# CITY OF ALBUQUERQUE

October 10, 2017

**RE: Desert Sands Subdivision Temporary Pond on  
Track A-1-C Bulk Lands of Salazar Family Trust (N09D014)  
Notice of Failure to Maintain**

TITLE: **DESERT SANDS SUBDIVISION
DRAINAGE PLAN**

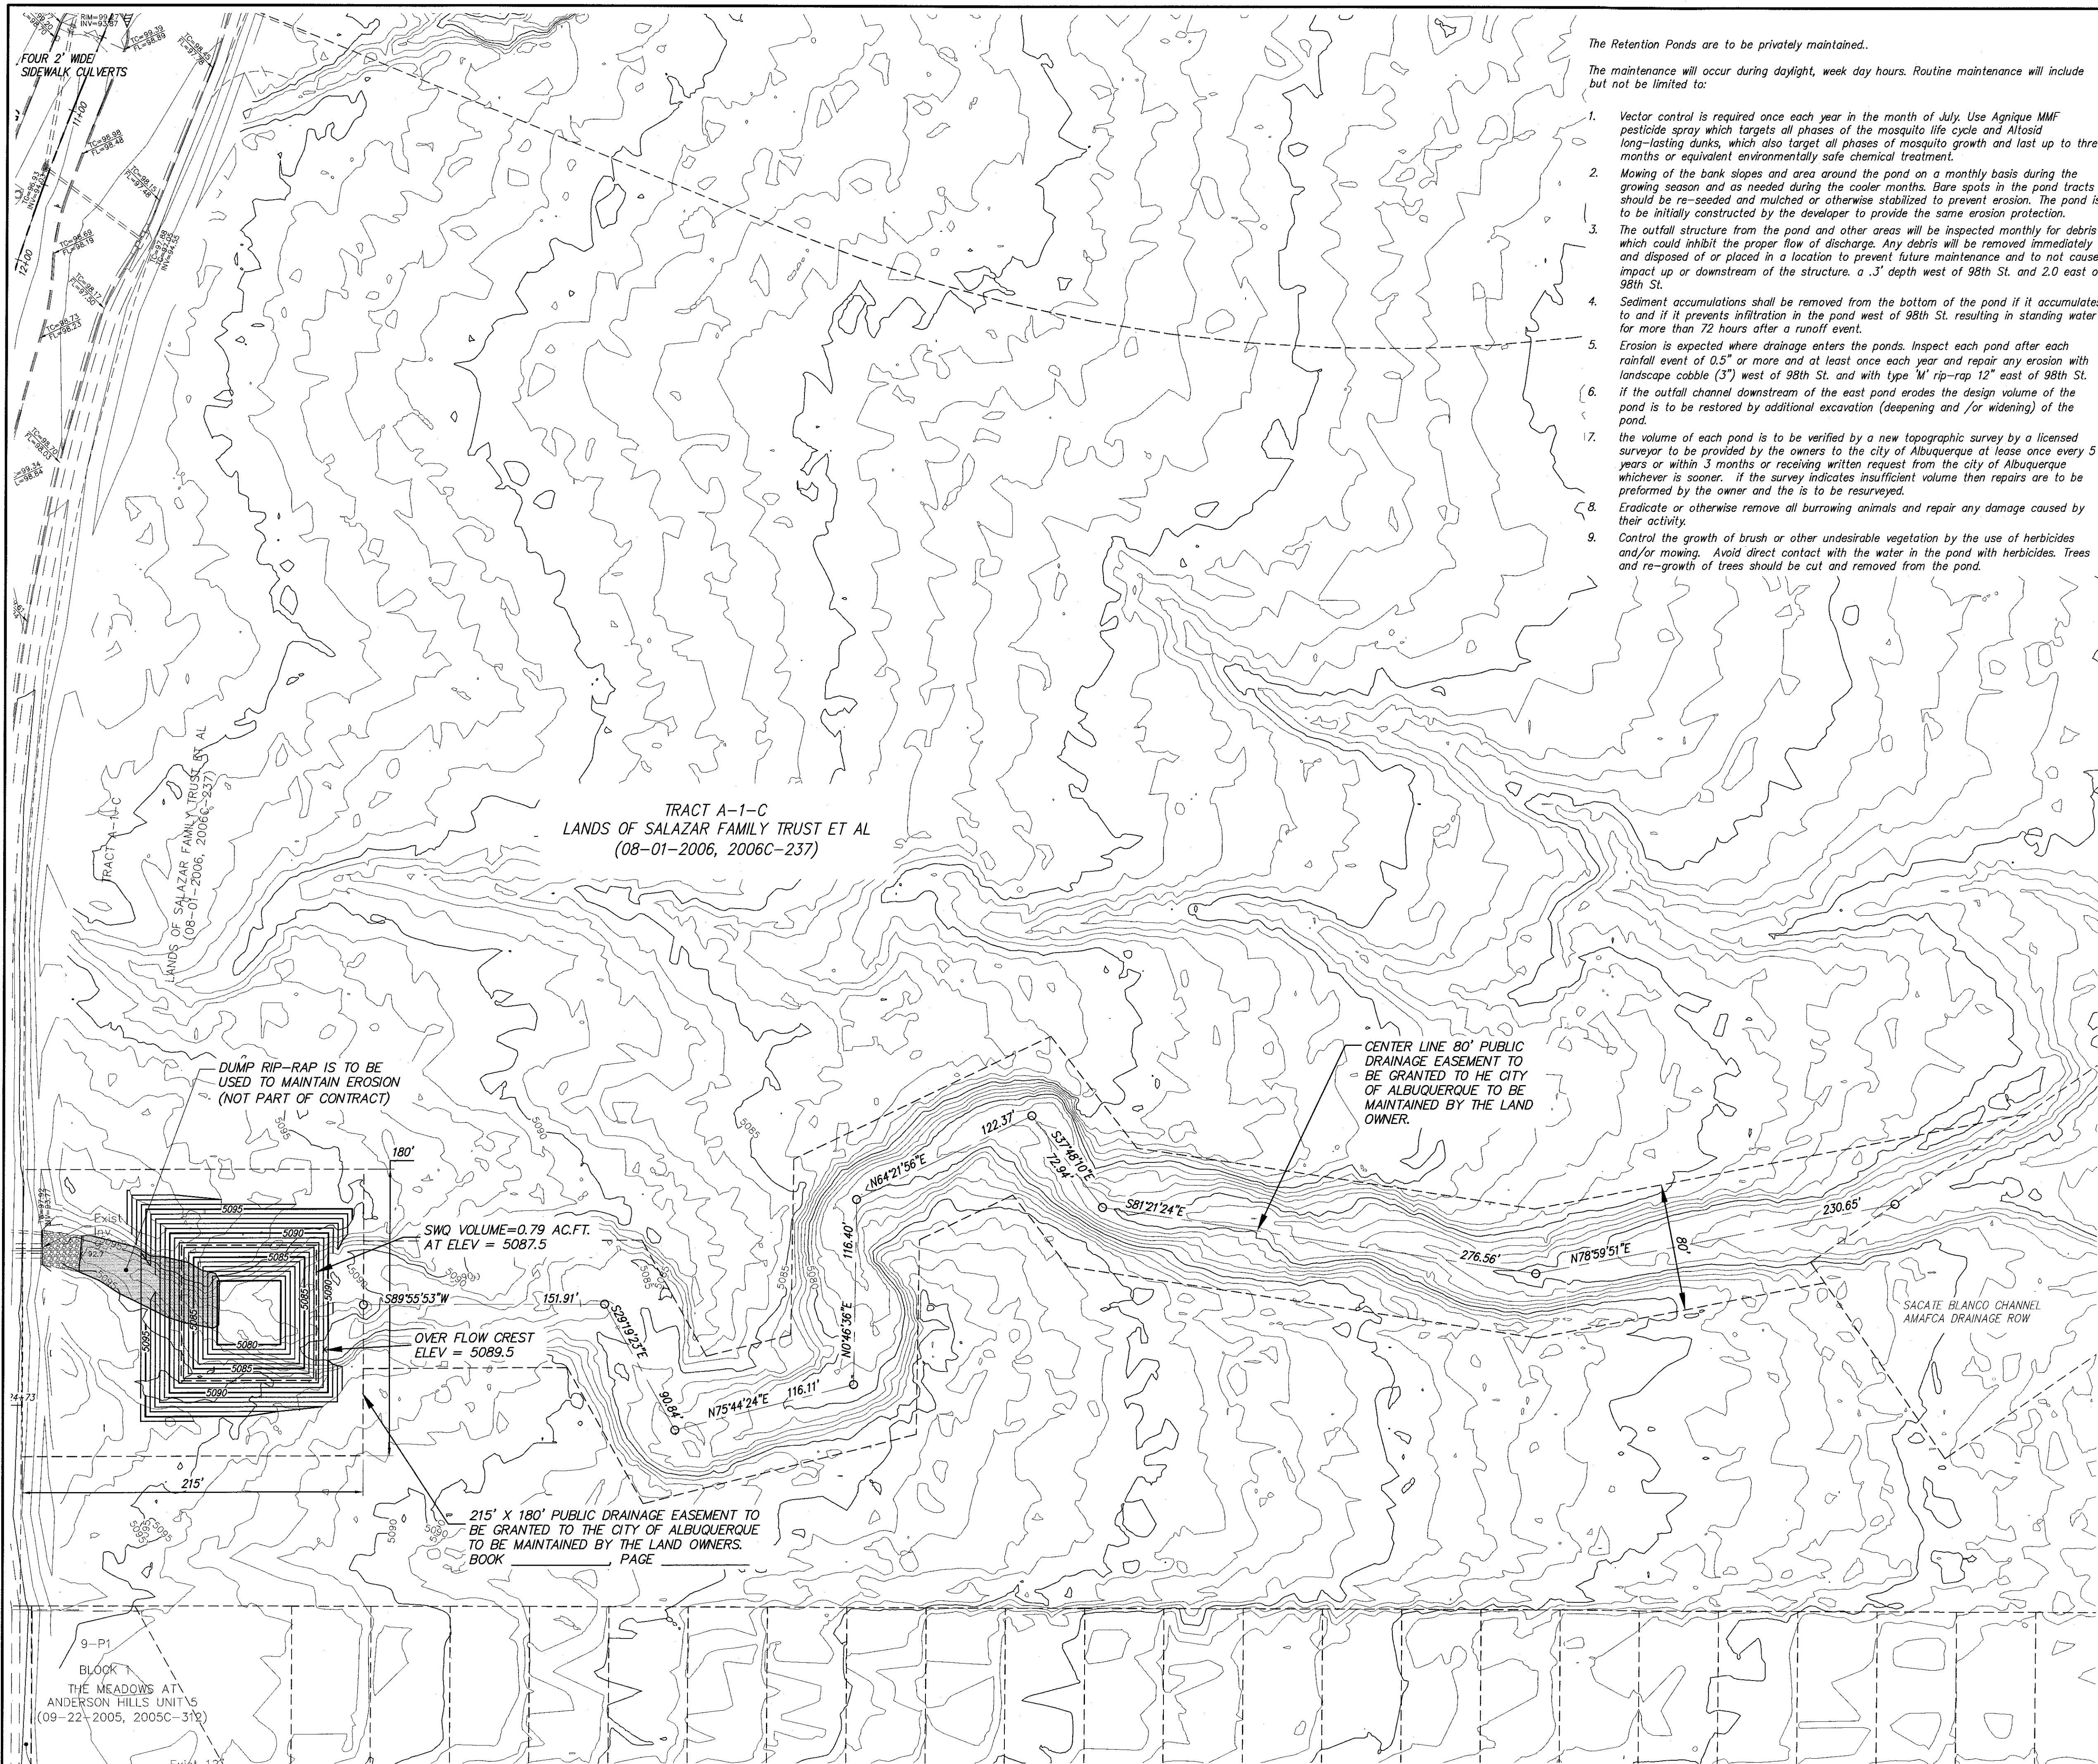
Erosion at the pond has occurred much faster than originally anticipated and is already threatening the City's storm drain under 98<sup>th</sup> st. Before construction started the wire enclosed rip-rap was buried so that only the top was exposed. Now the dirt has eroded to the bottom of the wire enclosed rip-rap.

The erosion on all sides of the wire enclosed rip-rap is caused by LGI's construction of the temporary water quality pond east of 98<sup>th</sup> St. Agreement and Covenant calls for dumped rip-rap to repair erosion which must be done immediately. If the repair is not completed within 30 days from this notice the City has the right to repair the erosion and lien your property for the cost of the repair.

The grade on the north and south of the wire enclosed rip rap should be restored to an elevation at least 2' higher than the wire enclosed rip rap to contain the flow and direct it downstream. The grade downstream should also be raised to the same elevation as the wire enclosed rip-rap with the sides higher to contain the flow and direct it downstream.
